Application No: FG/62/26/HH
Site Address: 1 Greenways Crescent Ferring BN12 5EF
Description of works: Proposed detached garden room.

Thank you for your internet representation made on 27th August 2026 which has been recorded as an objection with the comments as follows:

PROPOSED SECTION 1:50

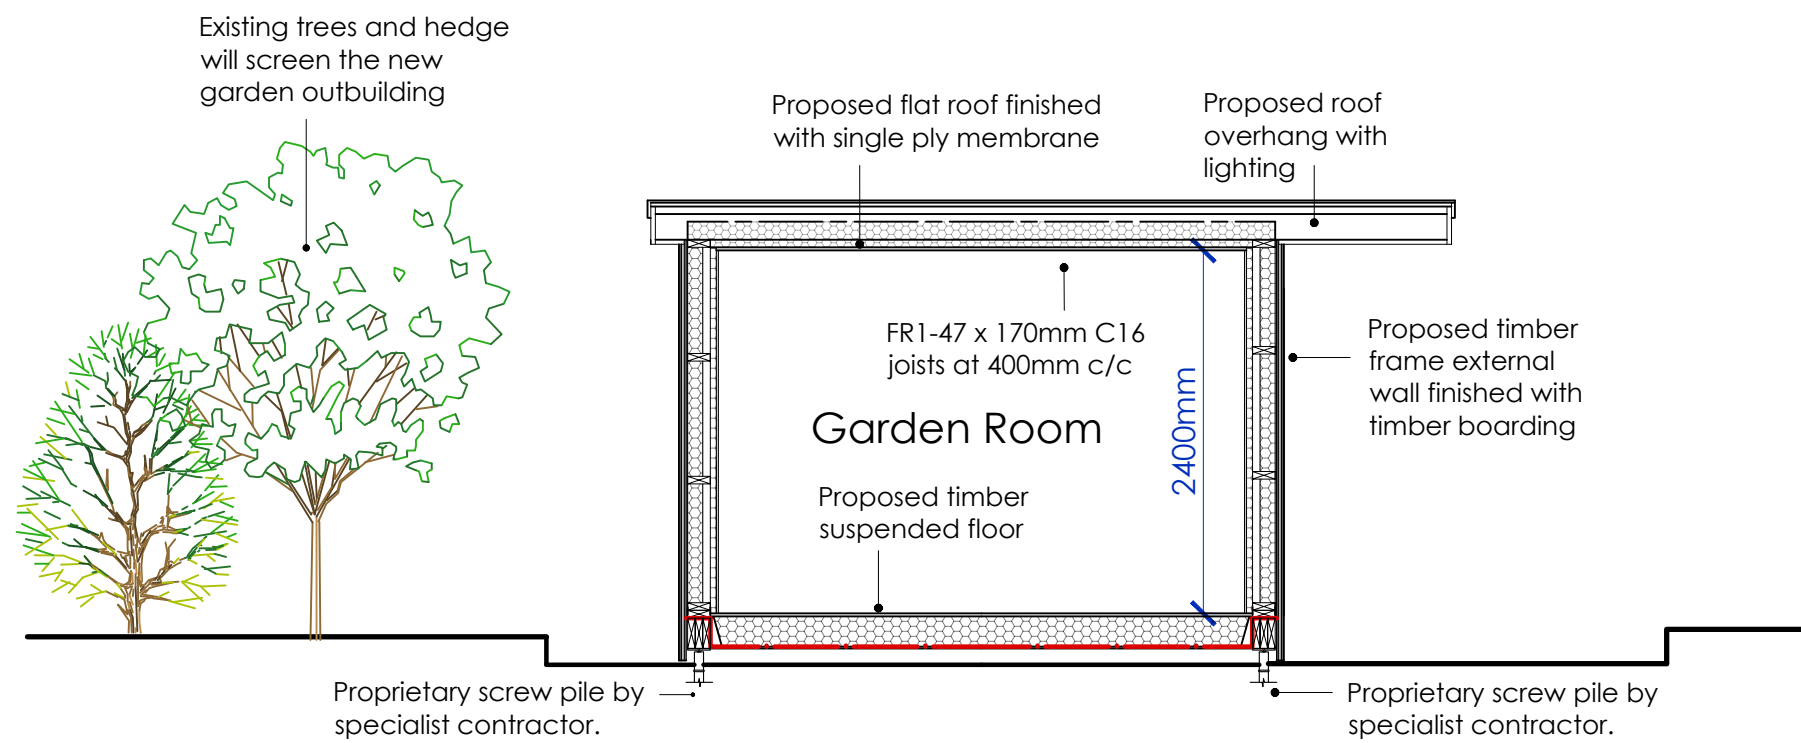
- Omission of External Dimensions: The plans only specify an internal floor-to-ceiling height of 2.4m. The critical external eaves height- which scales to just over 3 metres- has been omitted from the elevations, obscuring the true physical scale which may have mislead people viewing the application.

Drawing Number: AR-197-01

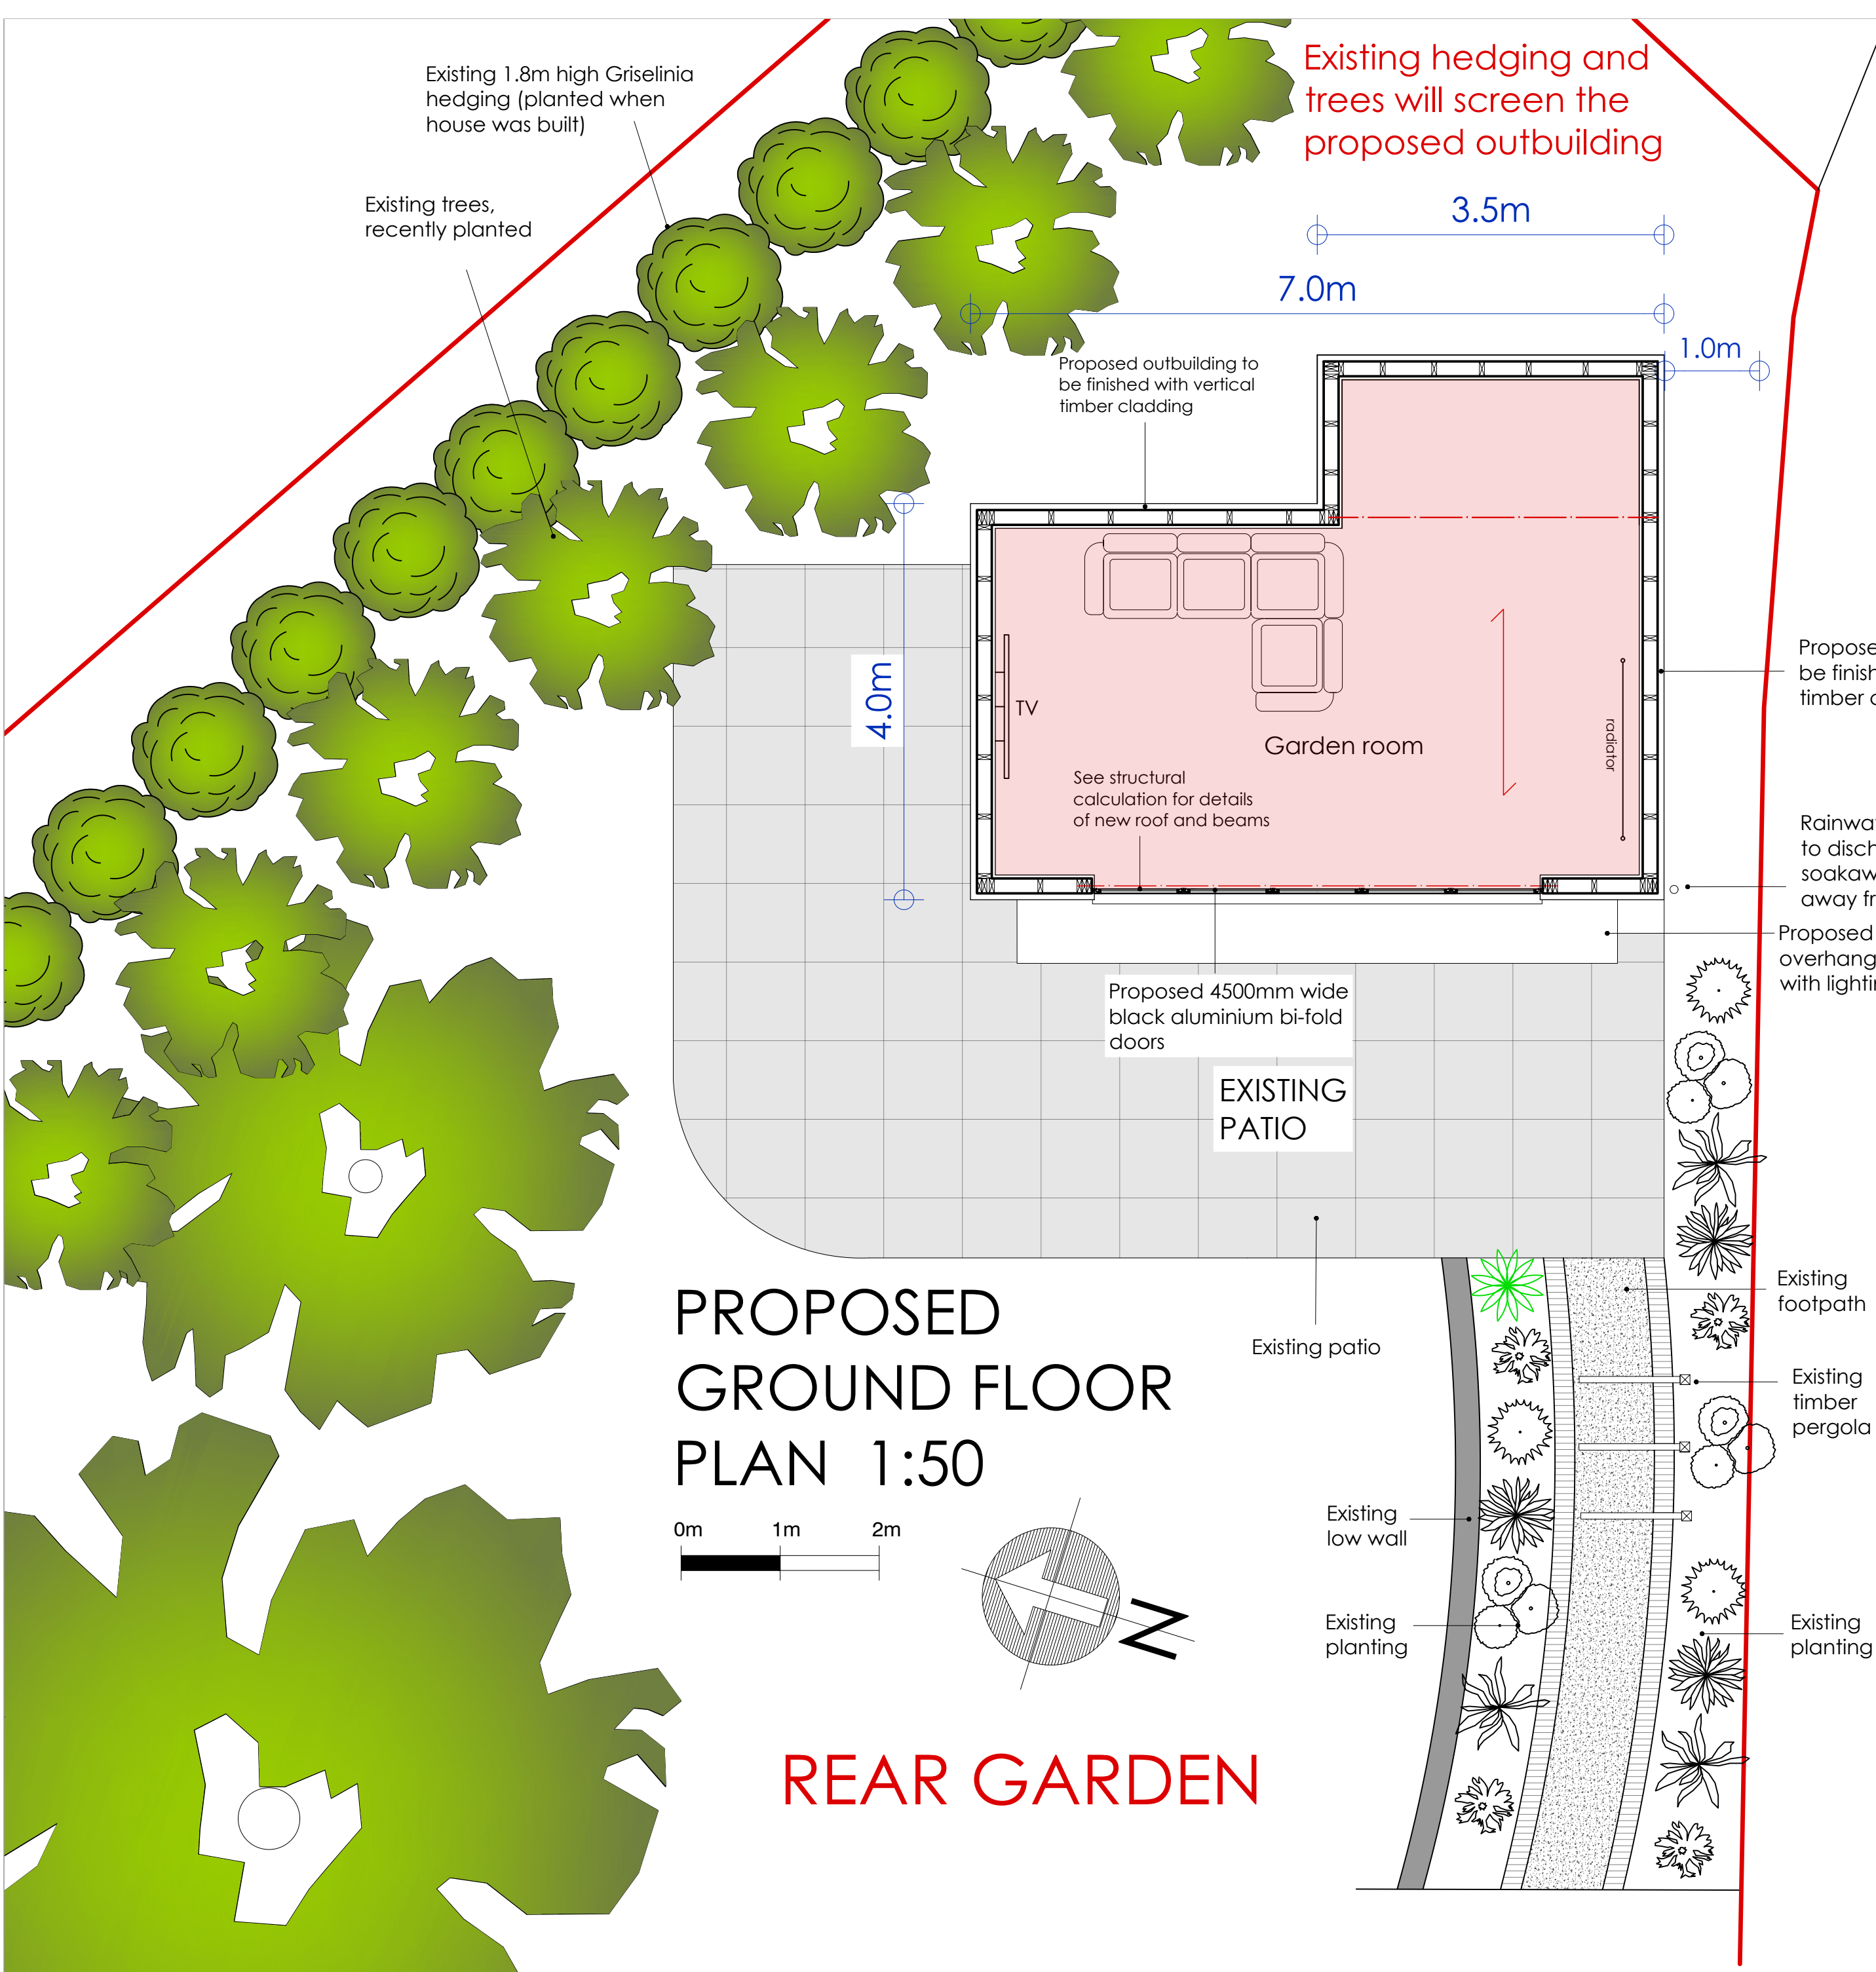
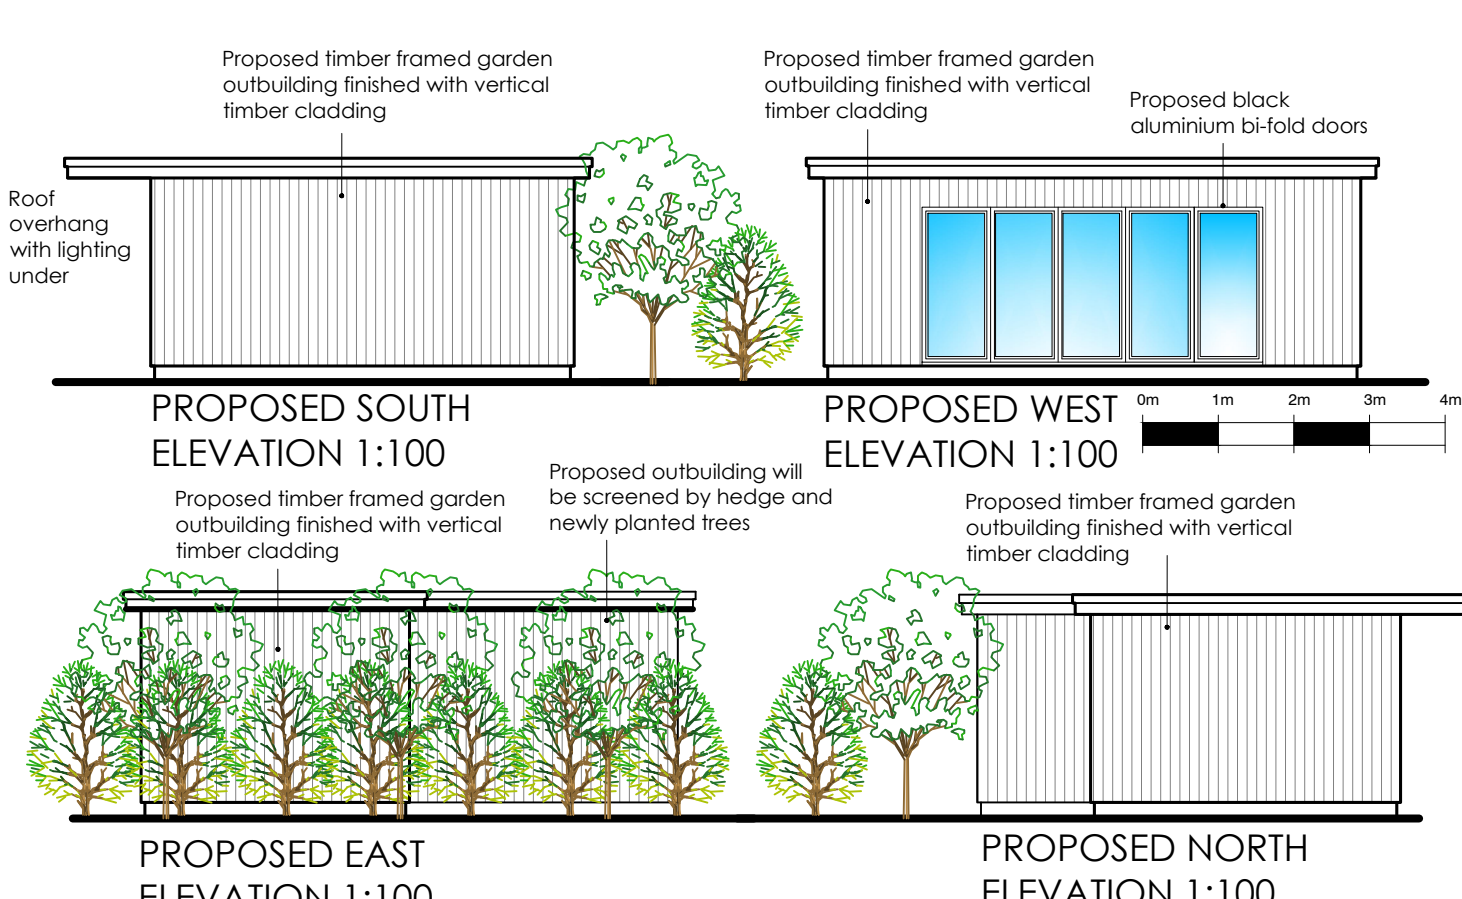
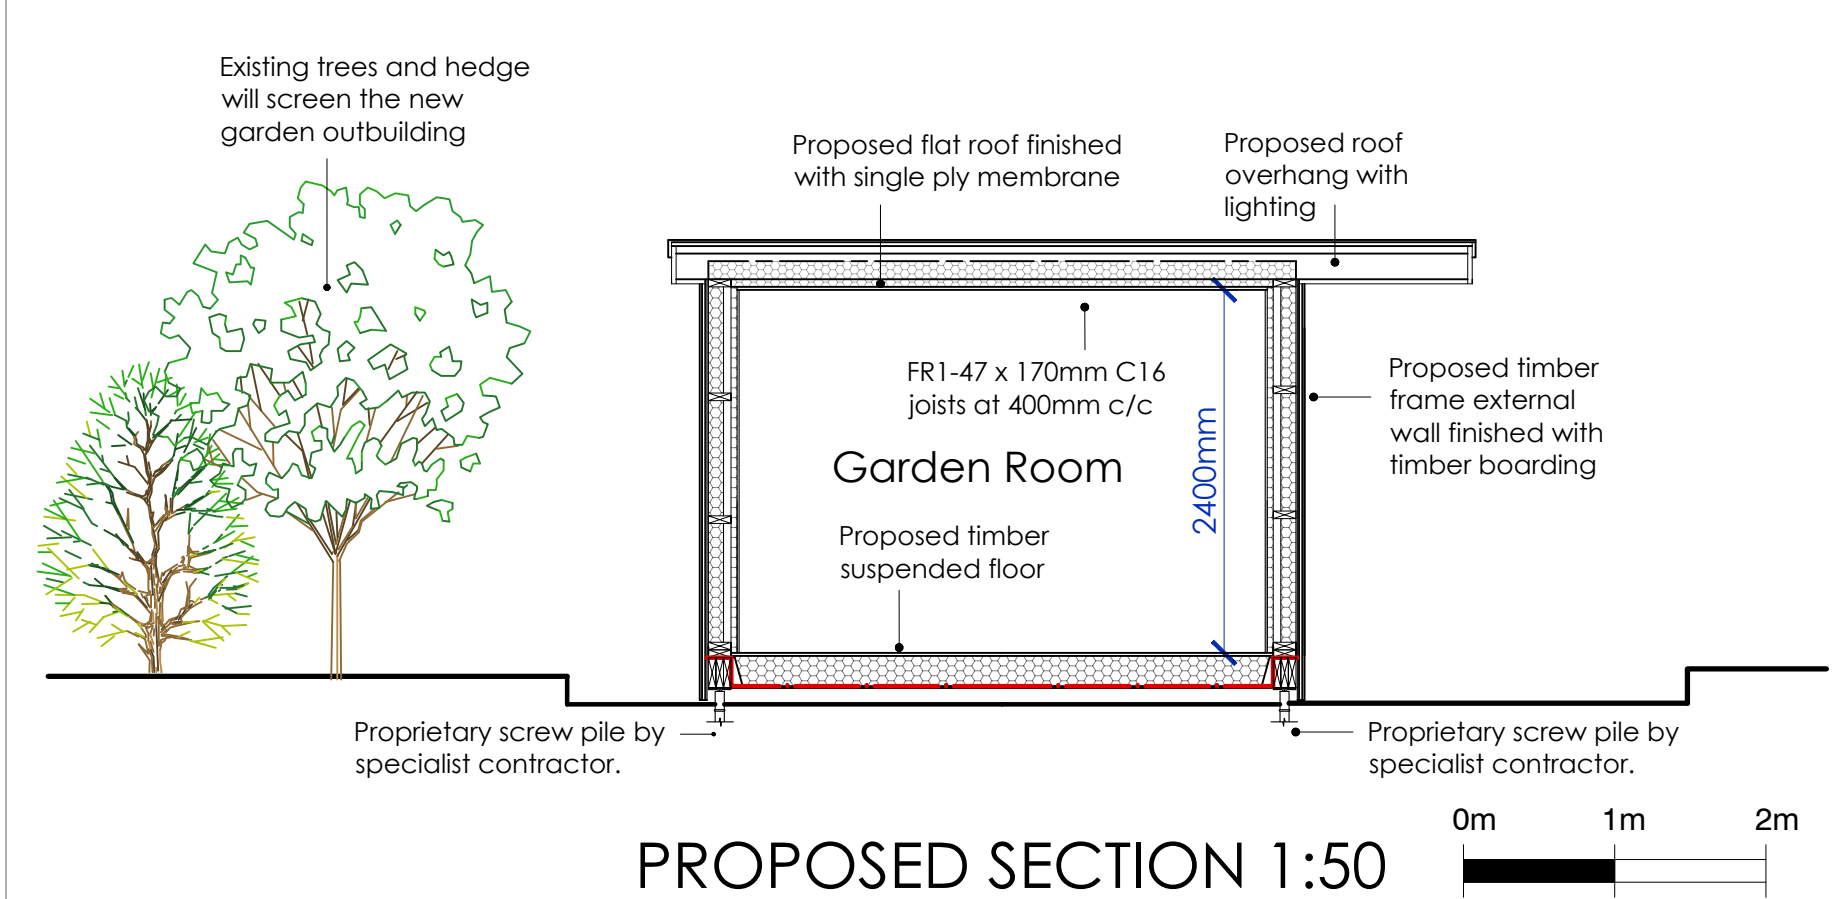
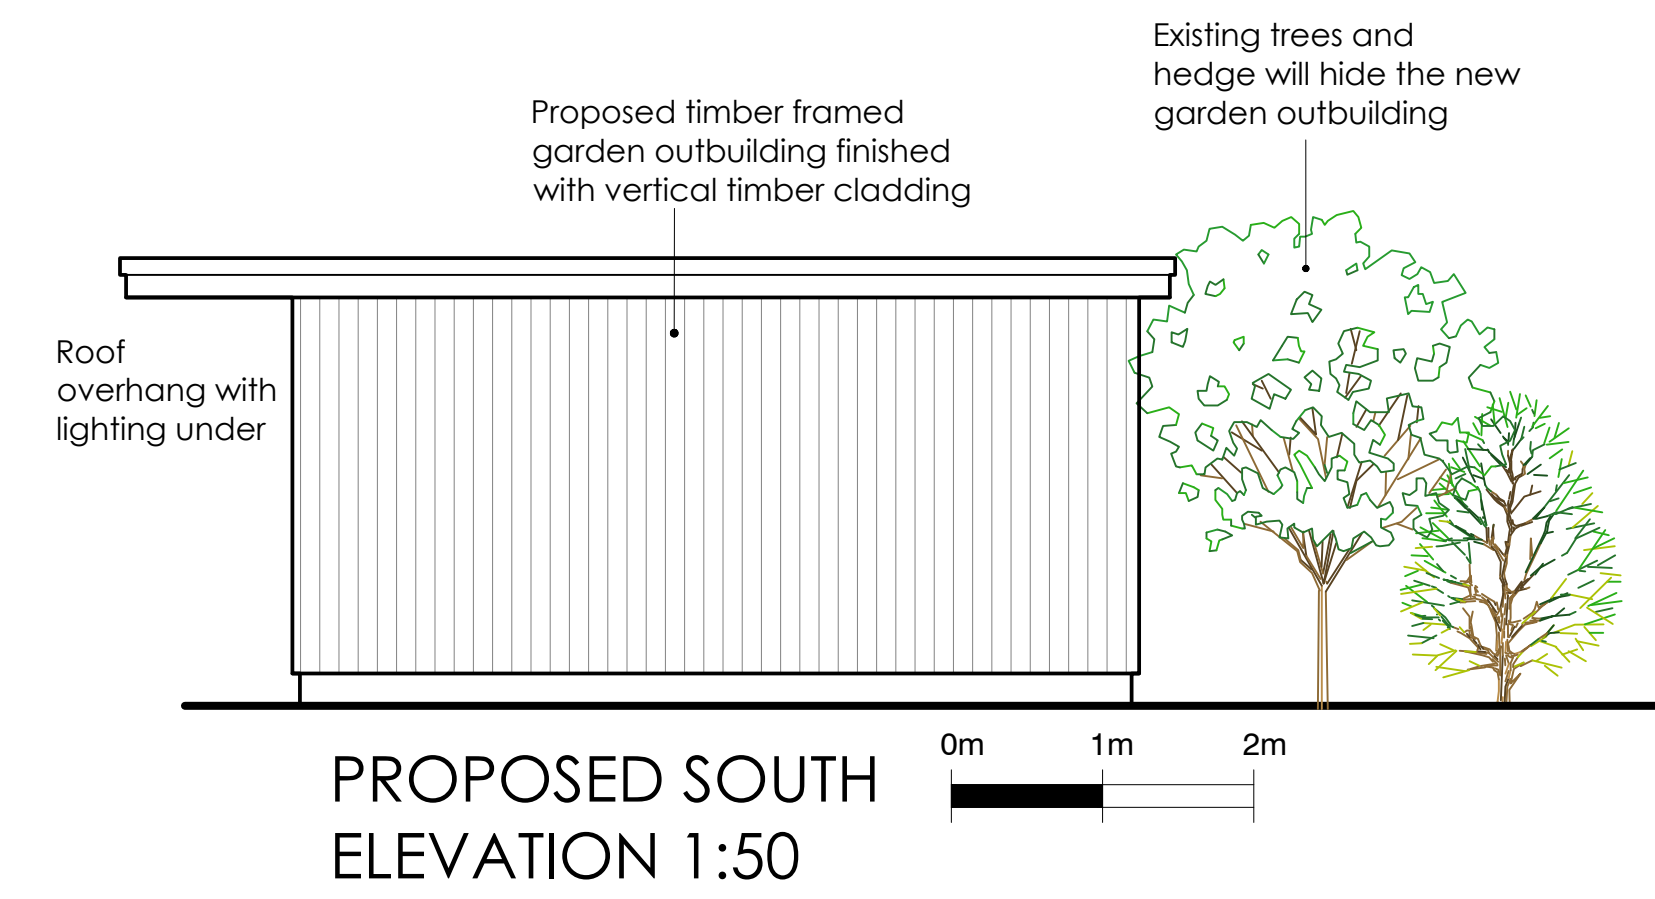
- Inaccurate Site Layout: The plan of the main house shows a section closer to the road that does not actually exist in reality.

- Irregular Dimensioning: Rather than showing a standard, direct perpendicular measurement to the highway boundary, an oblique dimension has been used to indicate the proximity of the proposed building to the road, which downplays how close the structure actually sits to the public viewpoint.
